16th September 2020

APPLICATION 20/02060/F – CHANGE OF USE OF LAND TO A MIXED USE FOR THE KEEPING OF HORSES (EXISTING) AND AS A RESIDENTIAL CARAVAN SITE FOR 4no GYPSY FAMILIES. EACH WITH TWO CARAVANS (INCLUDING NO MORE THAN 4no STATIC CARAVANS / MOBILE HOMES) TOGETHER WITH THE LAYING OF HARDCORE

CPRE Oxfordshire **objects** to planning application **20/02060/F** for the change of use of land at The Stables, Main St, Great Bourton, OX17 1QU, for the provision of 8 traveller site pitches.

# SITE LAYOUT PLAN

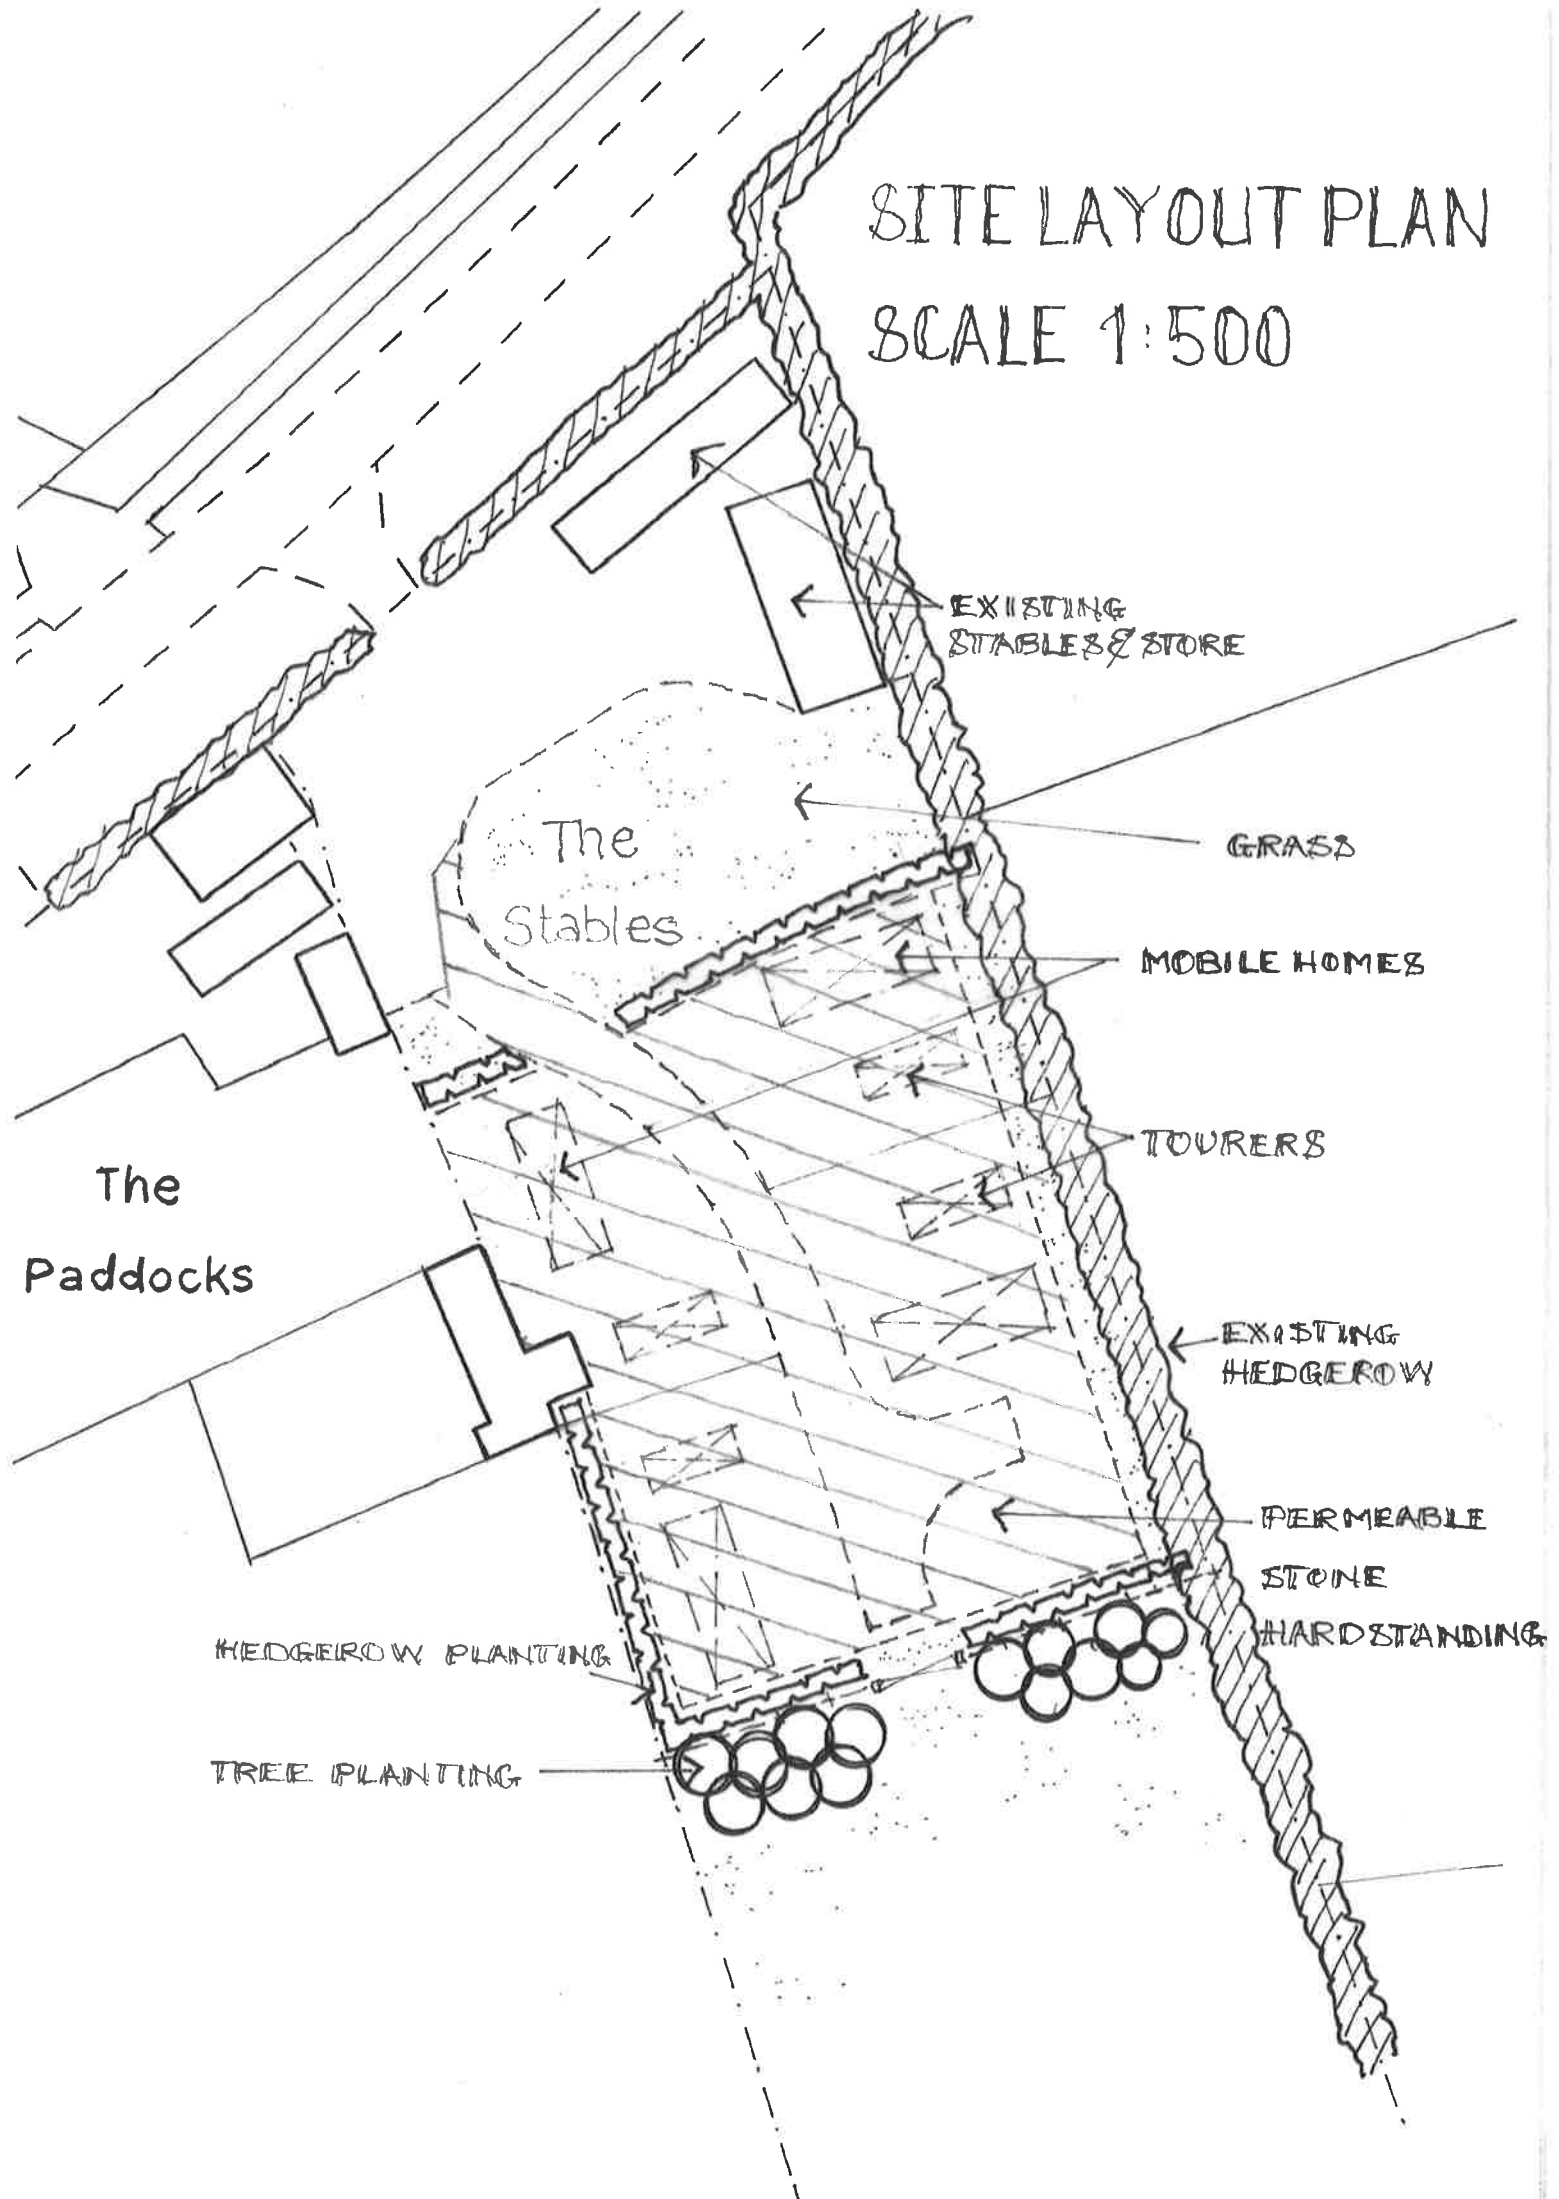
Whilst the site is not situated in a designated flood plain there is a history of flooding in the site area following periods of intense rain. There is no reason why this pattern should change and the laying of hardcore will only exacerbate the situation. **Therefore this site is unsuitable for the proposed development.**

A public footpath currently runs through the site. This not referred to in the application let alone a proposed re-routing. **This is not acceptable.**
